**Preliminary Arborist Report
DRAFT**

To: JMK Homes c/o Jed Murphy
Site: 6610 E Mercer Way, Mercer Island, WA
Re: Tree inventory
Date: July 13th, 2022
Project Arborist: George White,
ISA Certified Arborist #PN-8908A
ISA Qualified Tree Risk Assessor
Reviewed By: Joseph Sutton-Holcomb
ISA Certified Arborist #PN-8397AM
Municipal Specialist, ISA Qualified Tree Risk Assessor
Referenced Documents: Topographic Survey (Pace Engineers, 6.6.2018)
Koneru Short Plat (Pace Engineers, Revised 4.12.2022)
Attached: Table of Trees
Tree Site Map

**UTILITY PLAN**

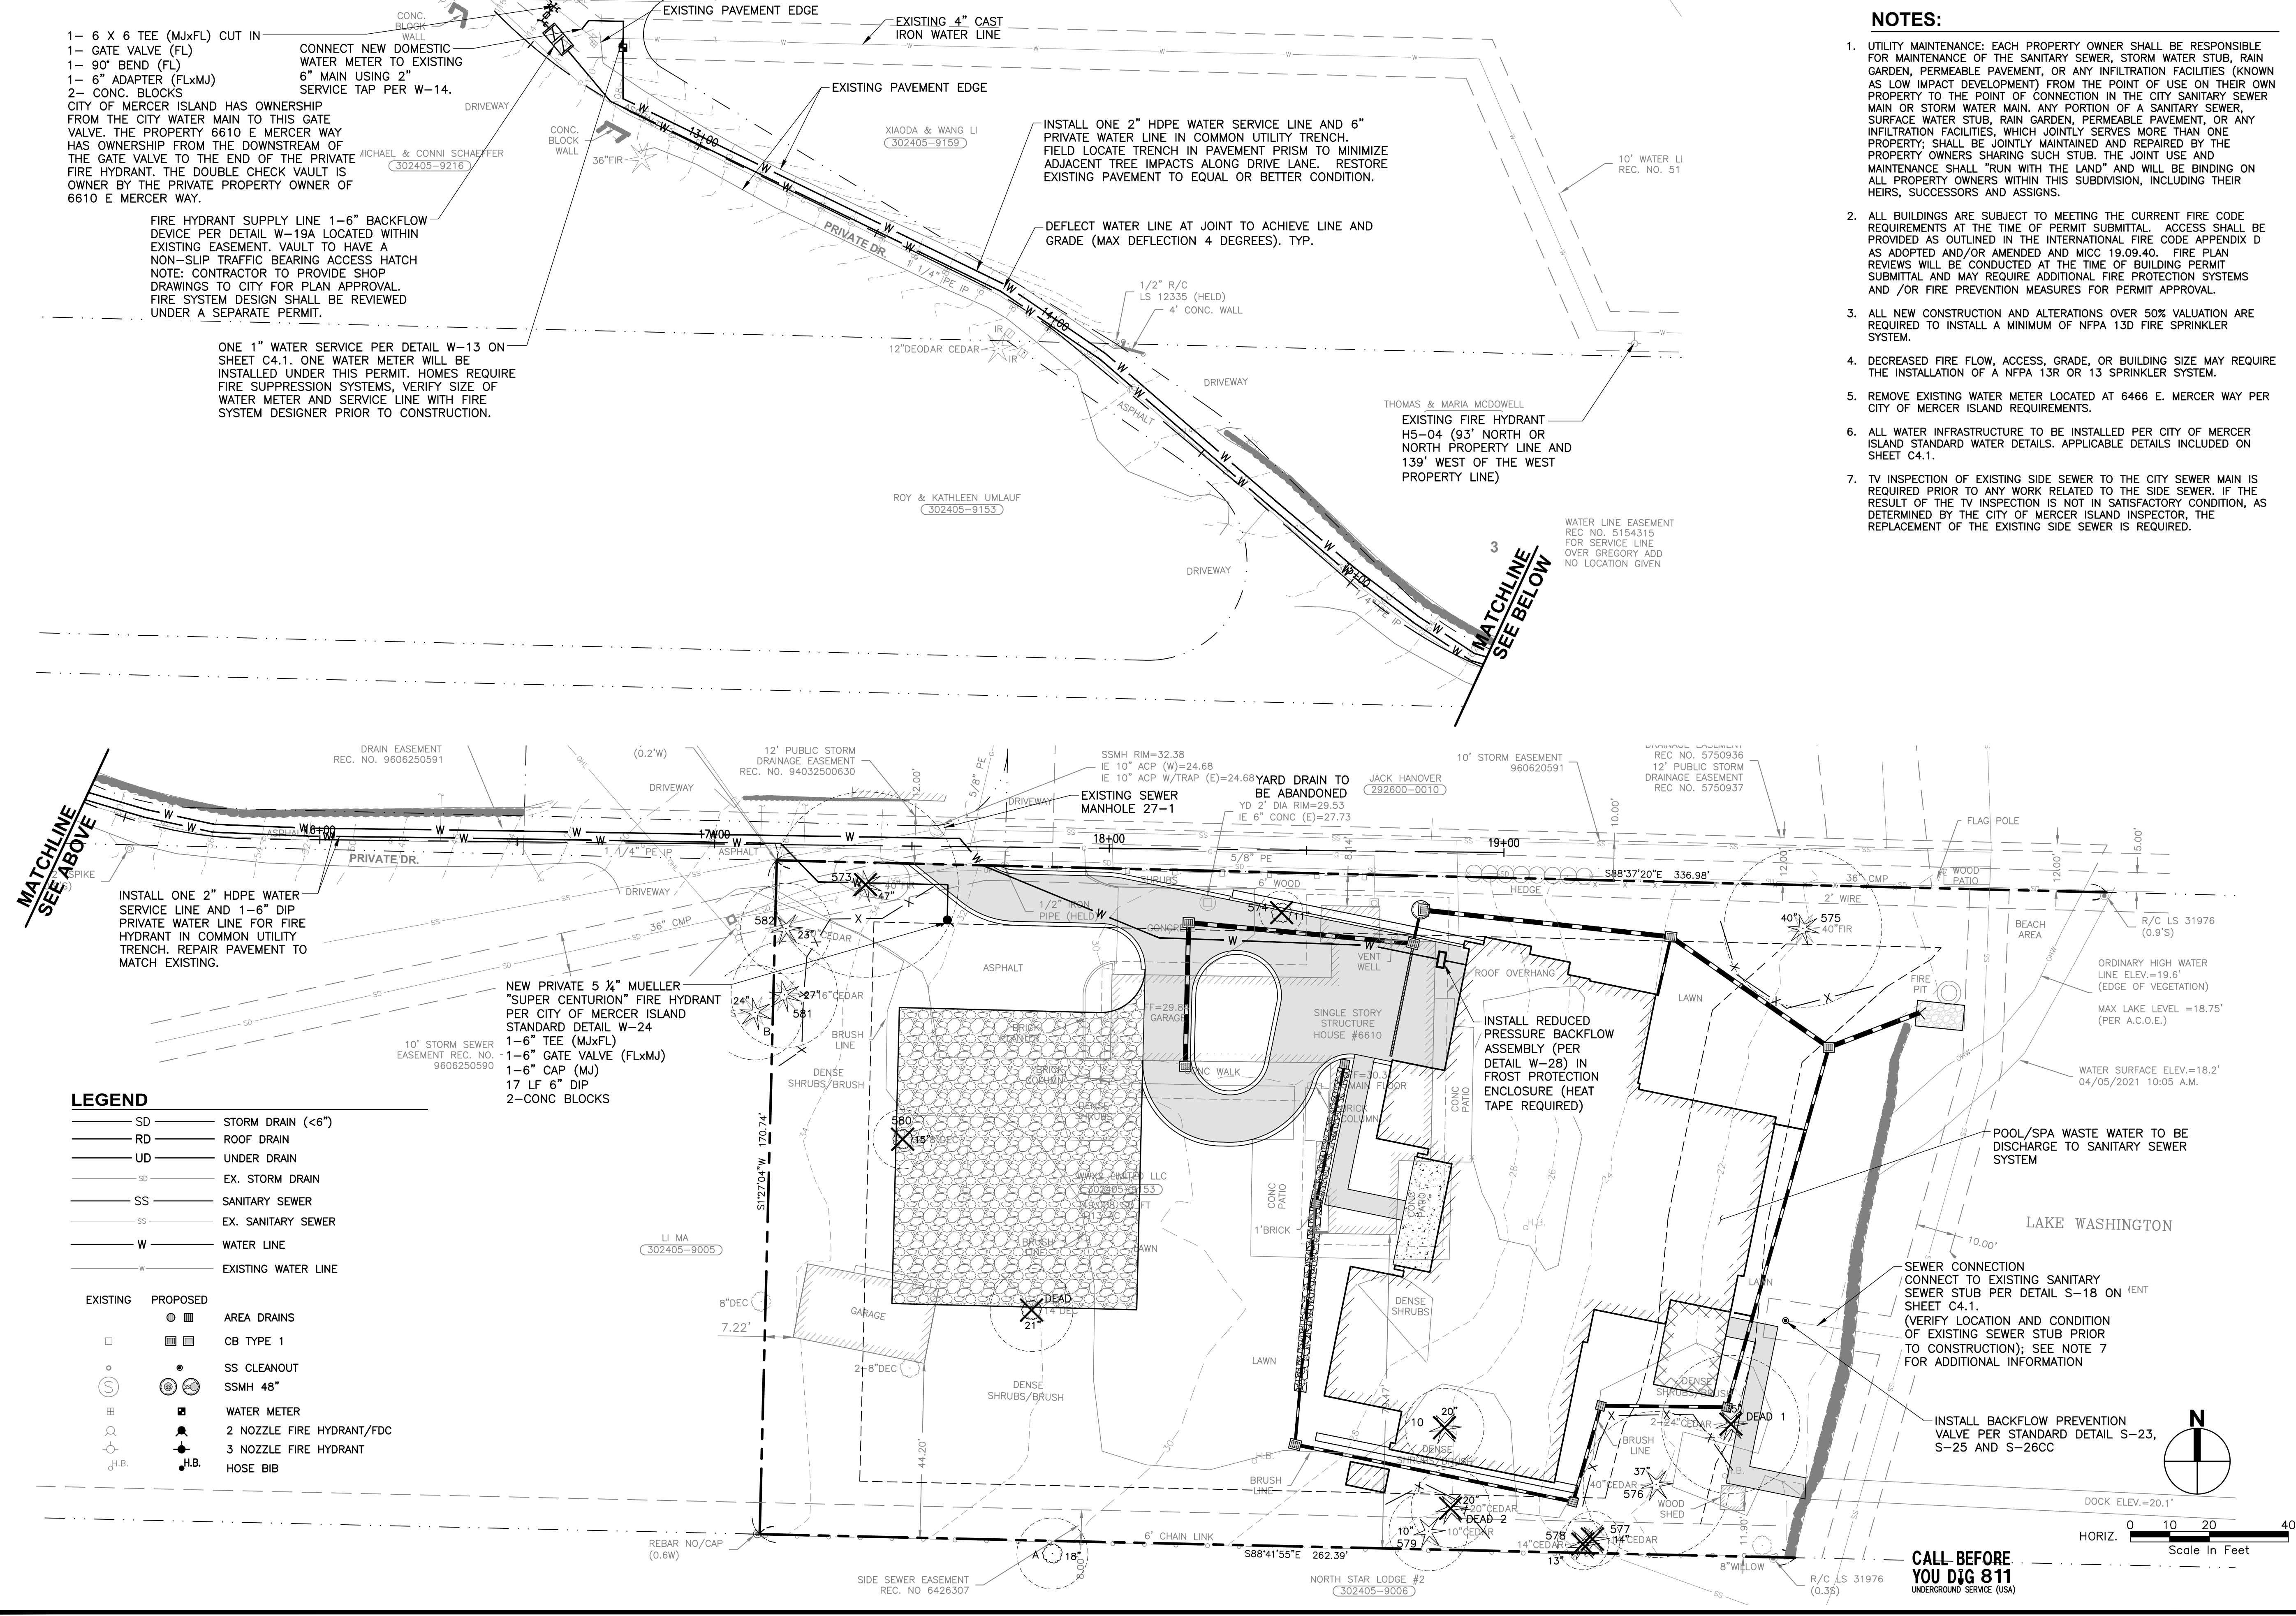
The most recent plans show a storm drain and catch basin located within the MLOD of dead tree 1. Retention of the tree would not be possible if it were alive under the current design. The storm drain and catch basin should be moved to the north (under the deck) outside of the MLOD for this tree. Moving the storm drain to this location would also reduce the impacts to tree 576.

Tree 575 is an exceptional Douglas-fir located north of the proposed structure. There is currently a proposed storm drain 10 feet from the base of this tree which is within the MLOD. This storm drain must be moved to 16 feet to be outside of the MLOD of this tree.

Tree 576 is an exceptional western redcedar located southeast of the proposed house. The most recent plans show that the storm drain is 17 feet from the base of the tree, which is just outside of the MLOD. Because of the existing grade, storm drain excavation is expected to be minimal across this area. I believe that root impacts due to this excavation to be minimal. Any excavation related to this storm drain is to be conducted by air excavation or by hand tools under arborist supervision.

Tree 573 is an exceptional Douglas fir located in the middle of the existing driveway. This tree is currently proposed for removal because it conflicts with the installation of the required fire hydrant. Although the fire hydrant itself is outside of the MLOD, it is required to be hooked up to a new 6-inch water line which parallels the existing driveway. A 6-inch waterline will require a minimum 4-foot trench. There is no way to install this water line without routing it through the MLOD of tree 573 (See Figure 1).

- Tree protection fencing on the plan set must be expanded to encompass the entire tree protection area for retained trees.
- Move storm drains and catch basins outside of the MLOD of all retained trees (including dead tree 1).
